# The Planning Inspectorate

Our Ref: TR010039

### **Application by Highways England for an Order Granting Development Consent for the A47 Wansford to Sutton scheme**

#### **Advice following issue of decision to accept the application for examination**

© Crown copyright and database rights 2020 Ordnance Survey 100030649. Use of this data is subject to terms and conditions.

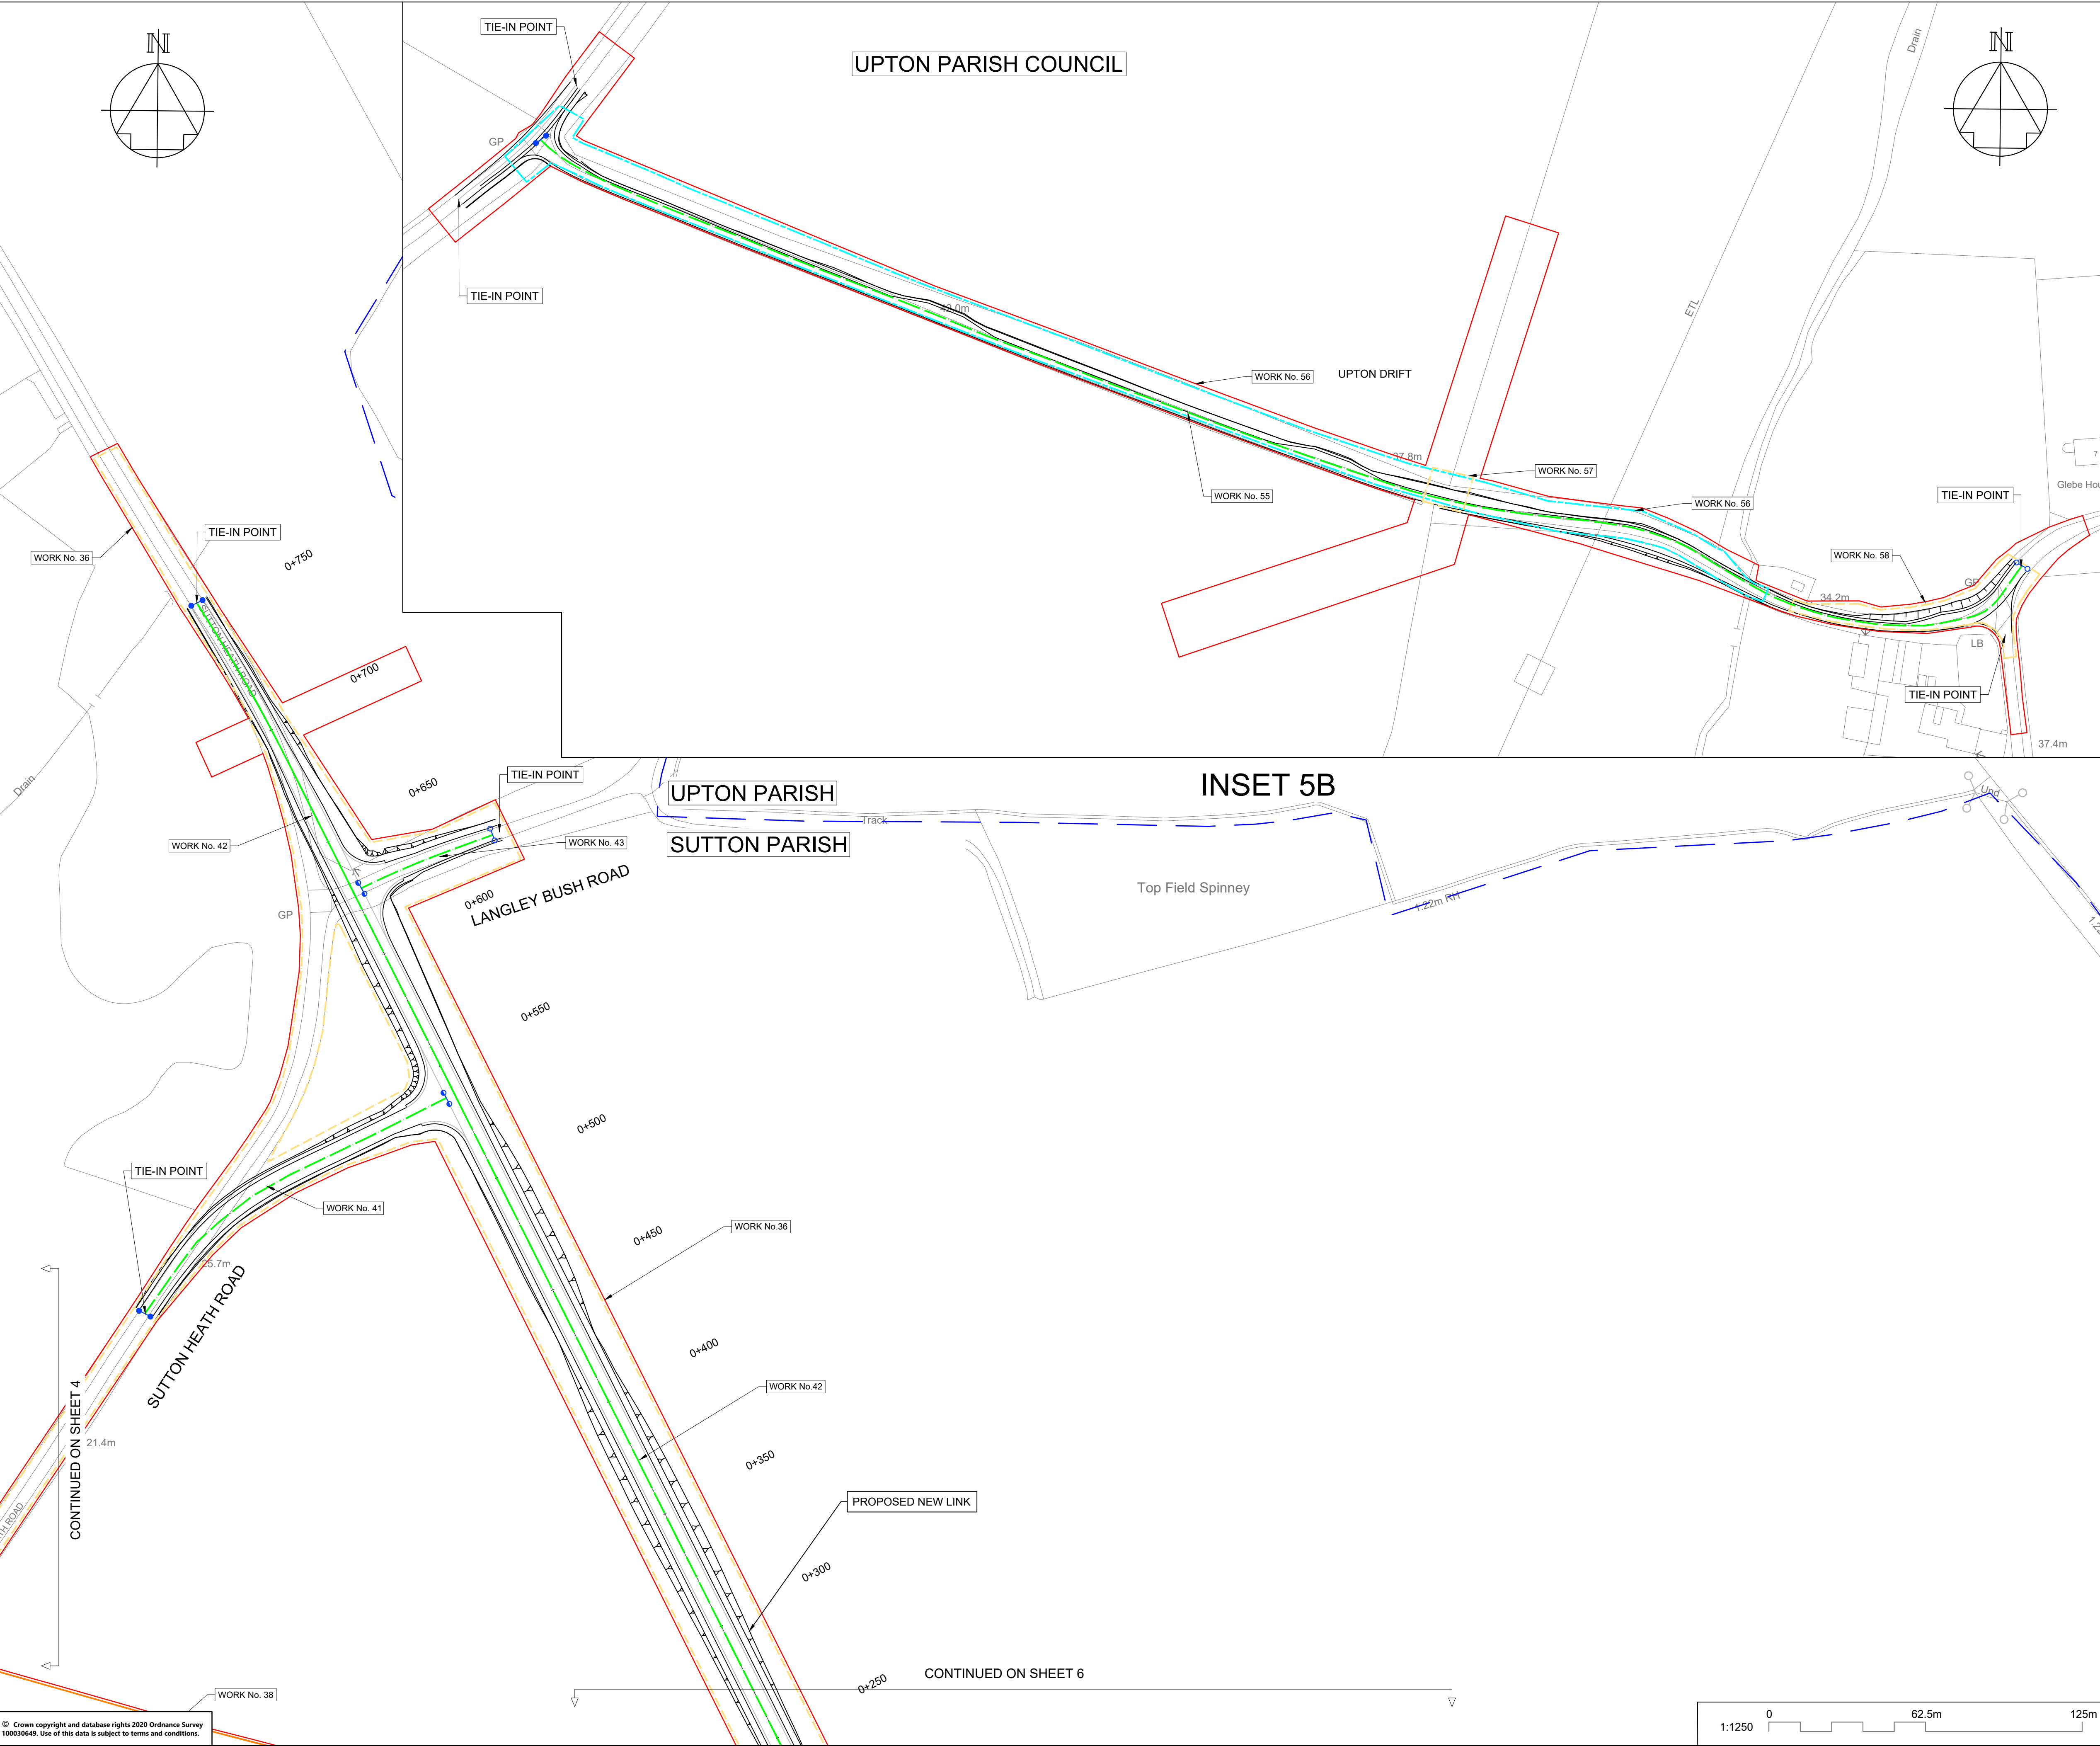
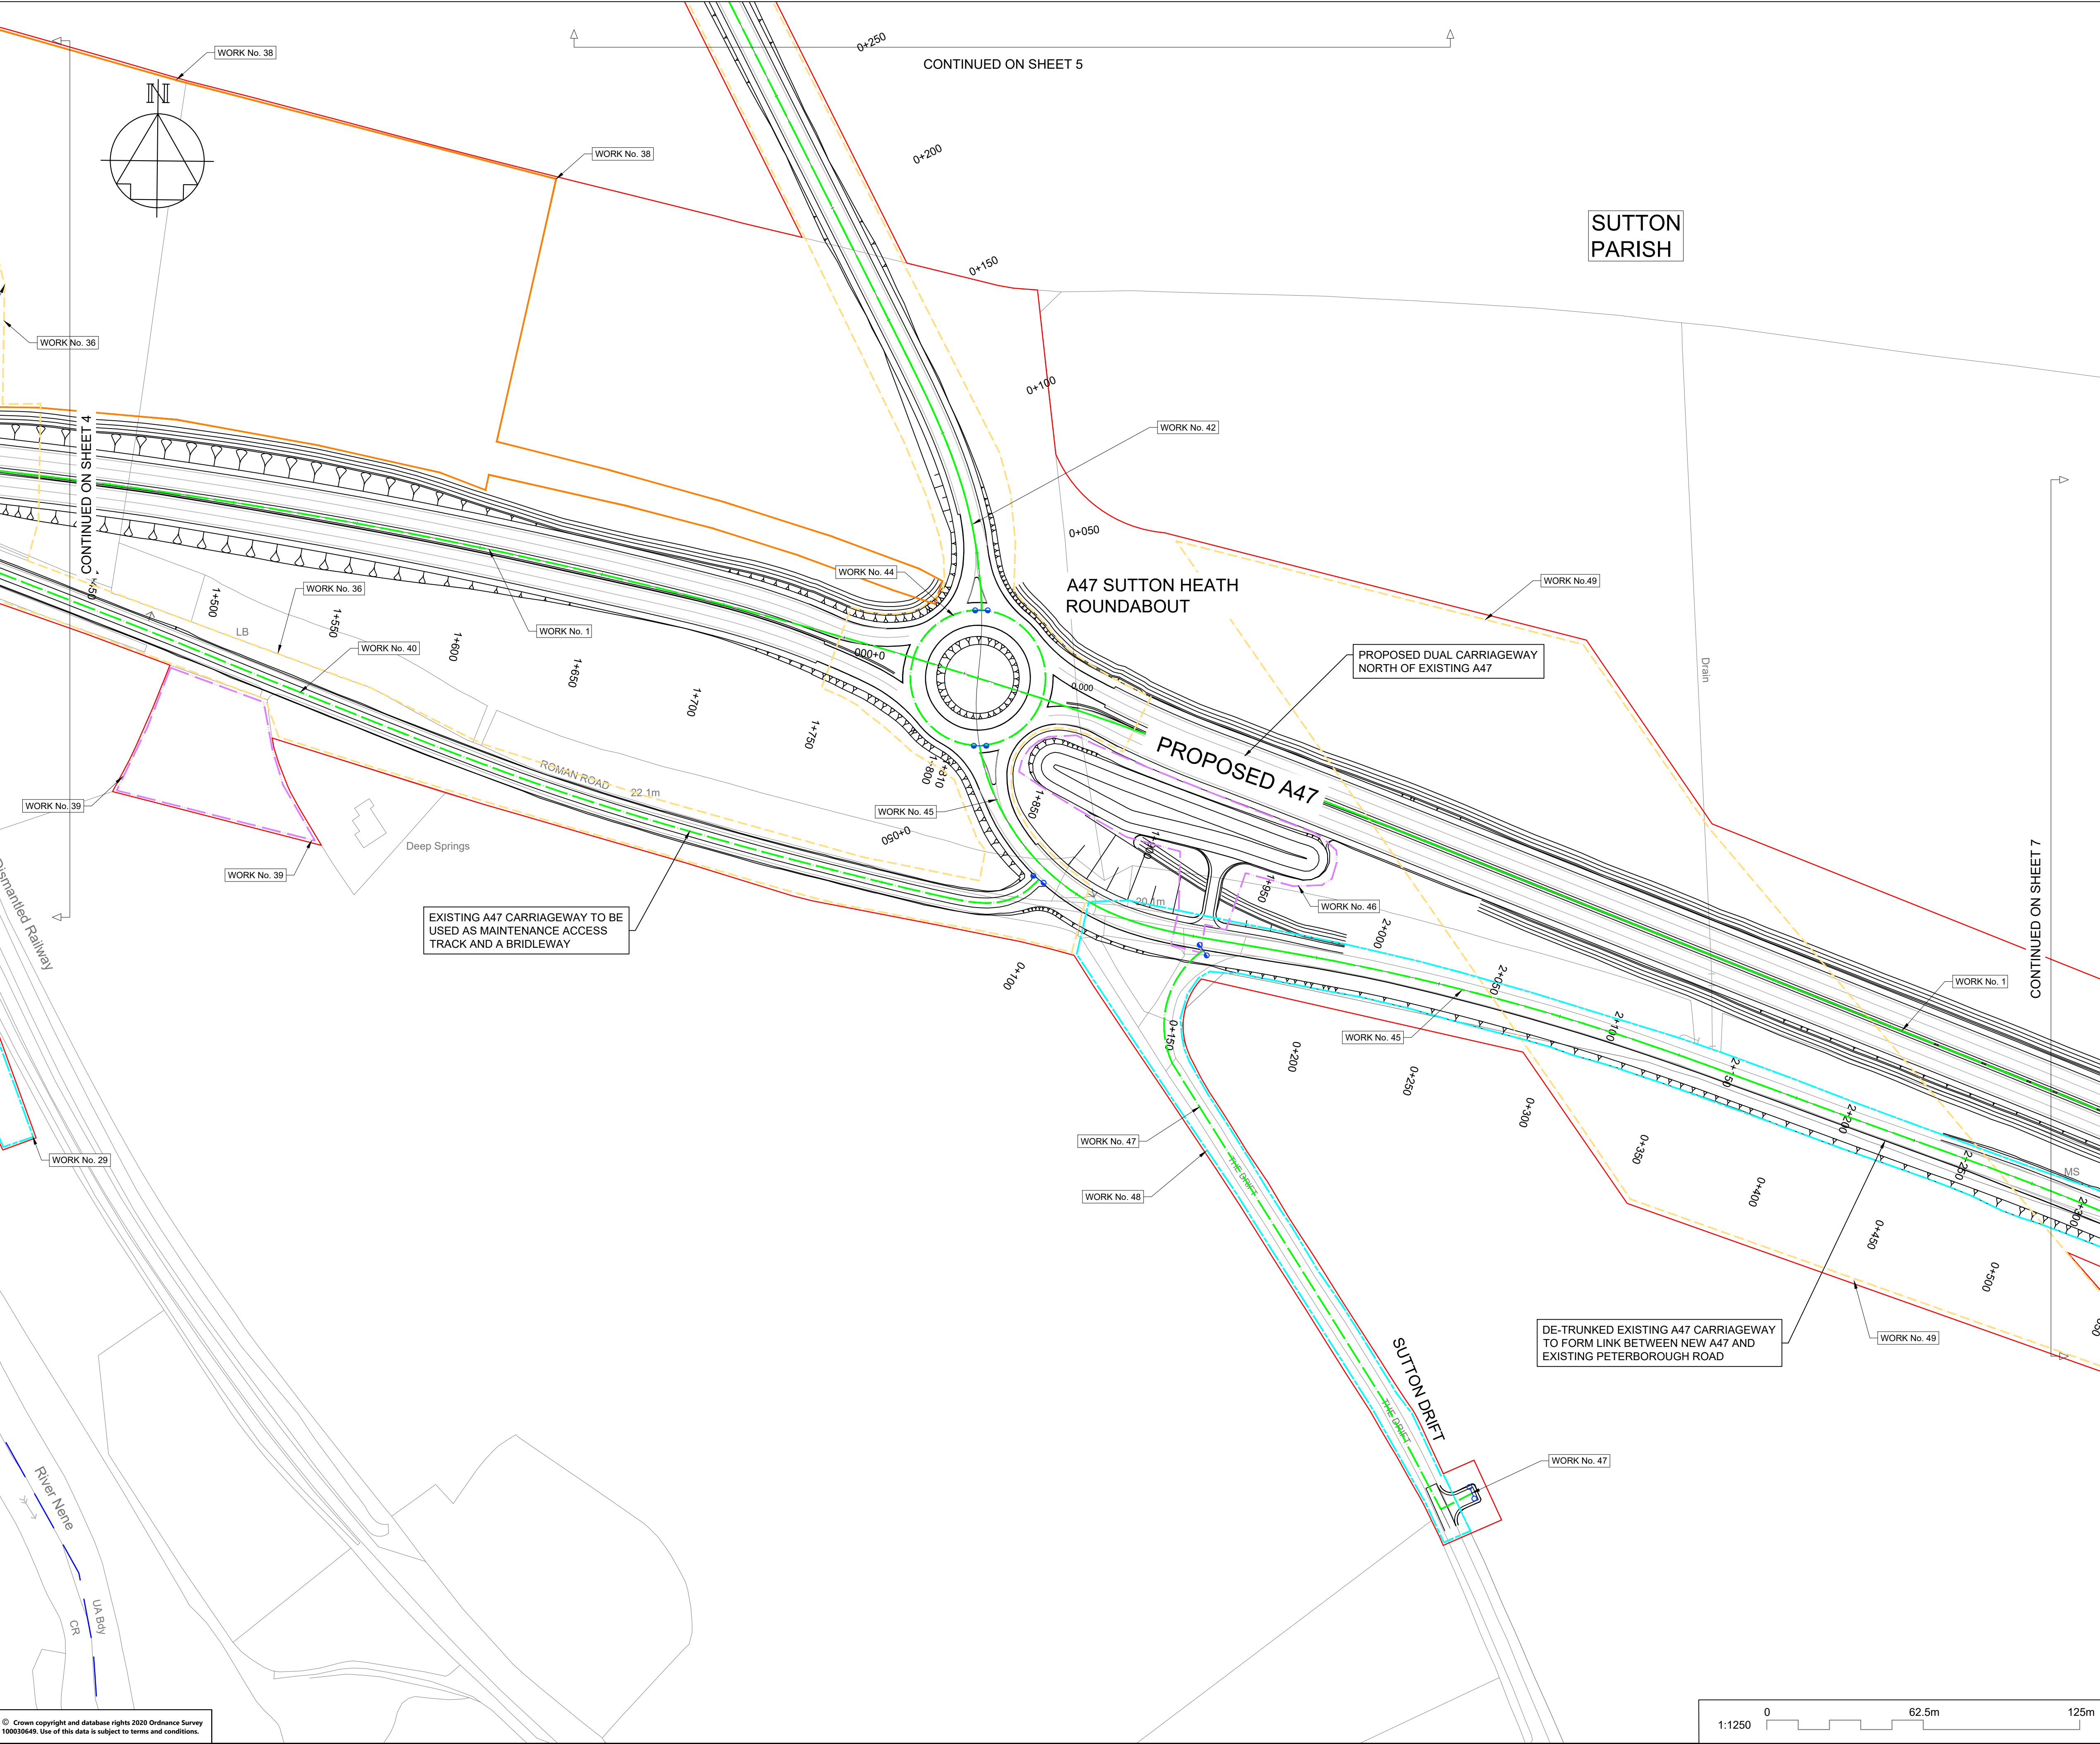
The Works Plans (Doc 2.3) do not clearly show the location and extent of the proposed compounds. The Inspectorate identified other minor discrepancies while checking the plans submitted as part of the application documents. Examples of errors are provided in Box 30, and the Applicant is advised to thoroughly check the plans for any corrections necessary. With this in mind the Applicant may want to consider submitting a revised set of Works Plans that:

- show the extent and location of the construction compounds; and

- represent the extent of the proposed works with annotations that are much easier to follow.
